17 July 2019

Our Ref: R/2019/2/A
File No: 2019/351568

SSD 9835 - Sydney Football Stadium (Stage 2 Design, Construction and Operation), 40-44 Driver Avenue, Moore Park

1 1:10 TERRACE STAIR TYPE 1 | PRECAST TERRACE SEATING | TYPICAL DETAIL SECTION TR1

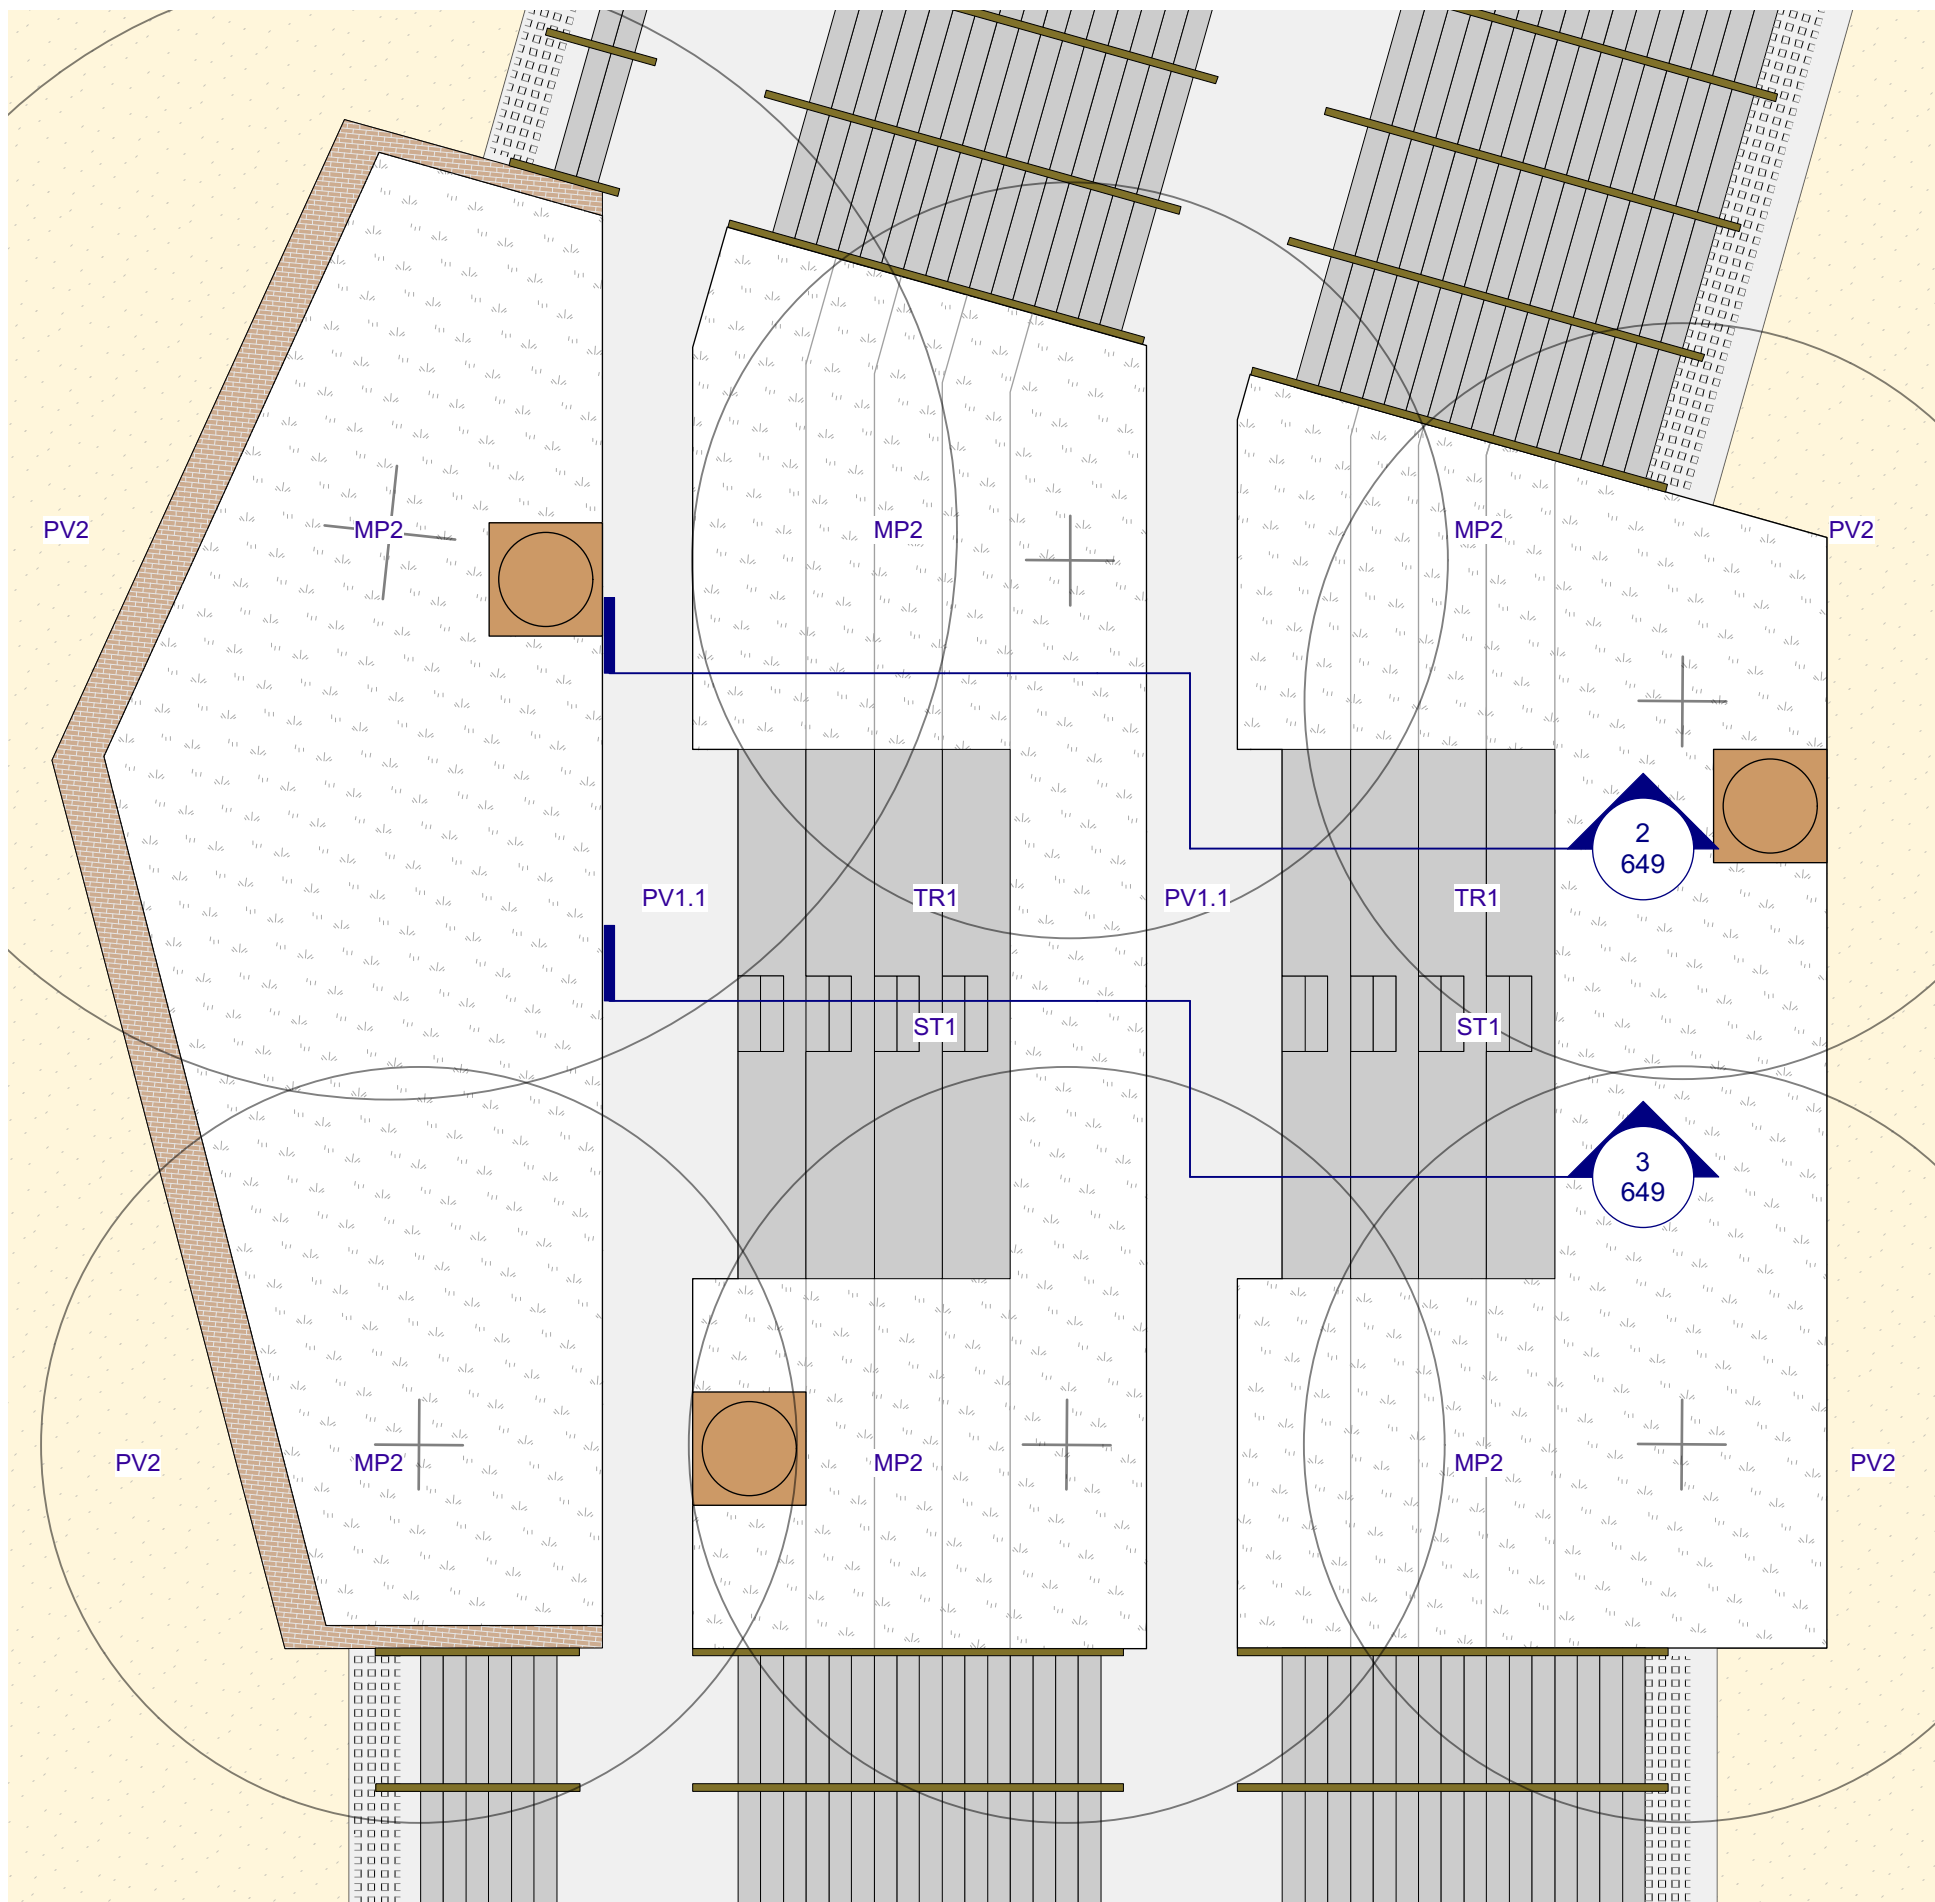
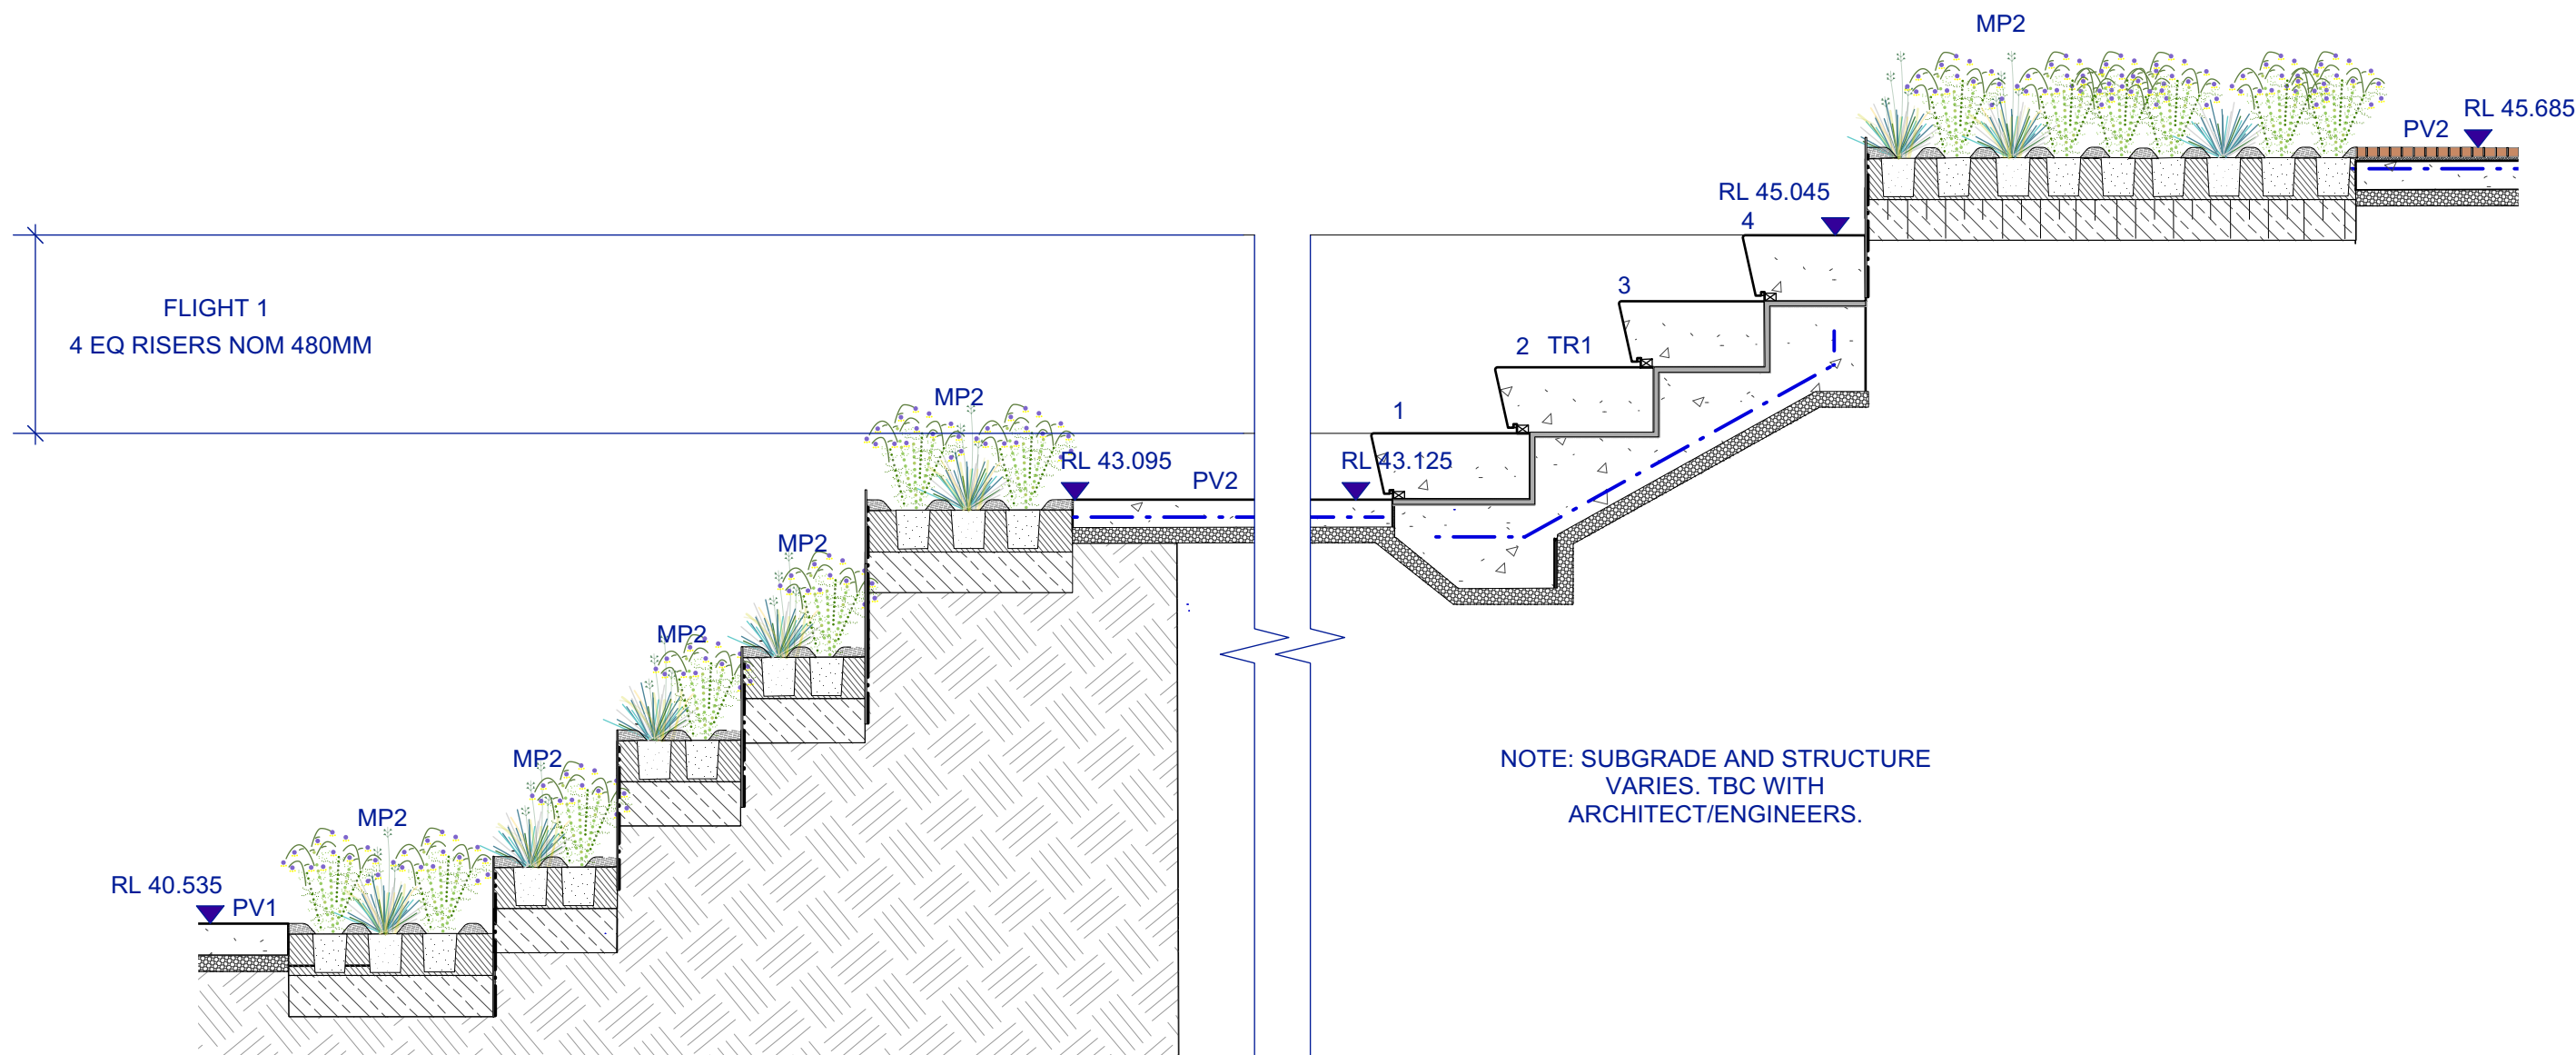
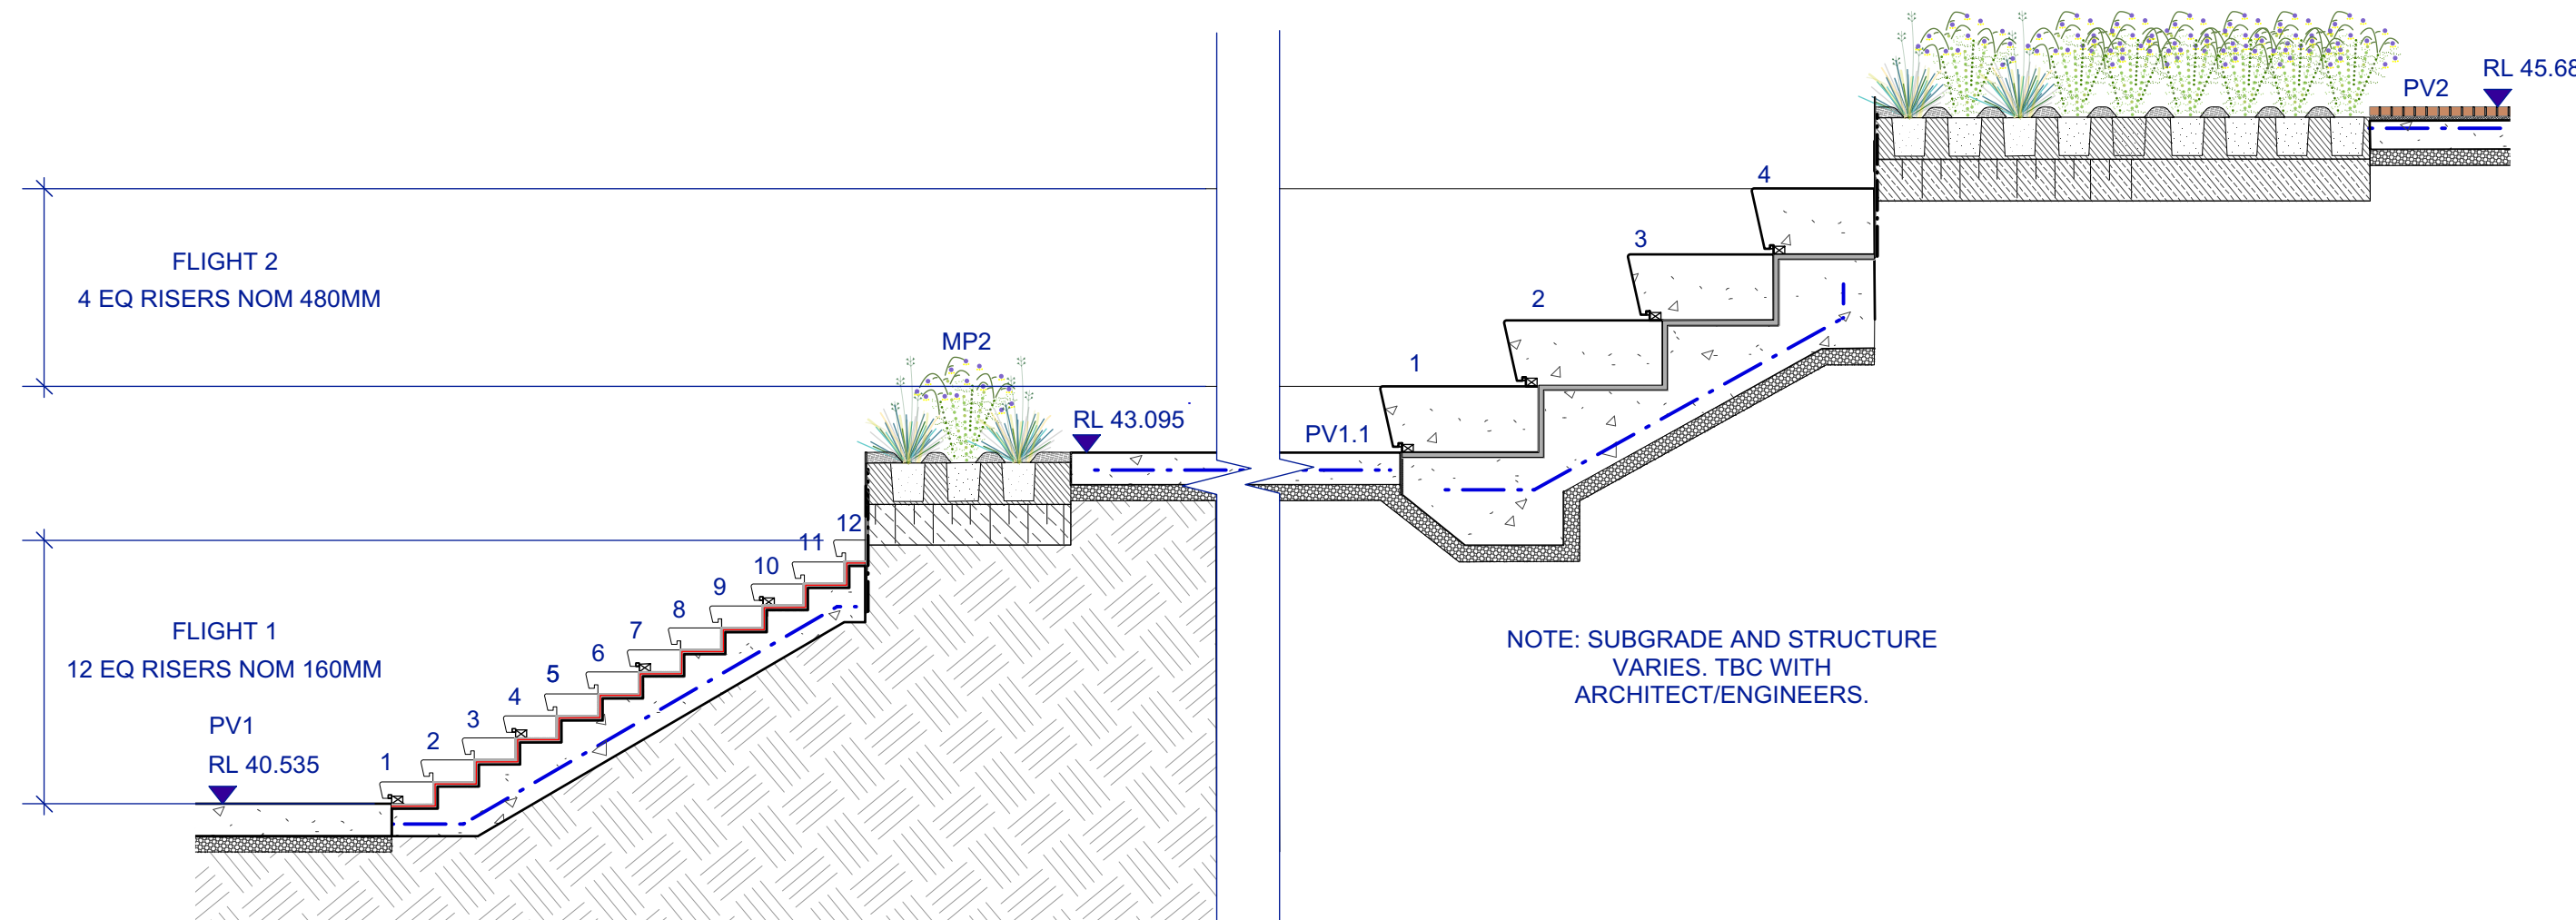
- Where seating terraces and integrated chairs are provided:
 - Ensure Tactile Ground Surface Indicators (TGSIs) are provided only at the top and bottom of the stair component to avoid people who are blind or have low vision confusing the seating terraces for stairs;
 - Instead of TGSIs at the top of seating terraces, consider the placement of planting or other elements to warn people who are blind or have low vision to travel another way.
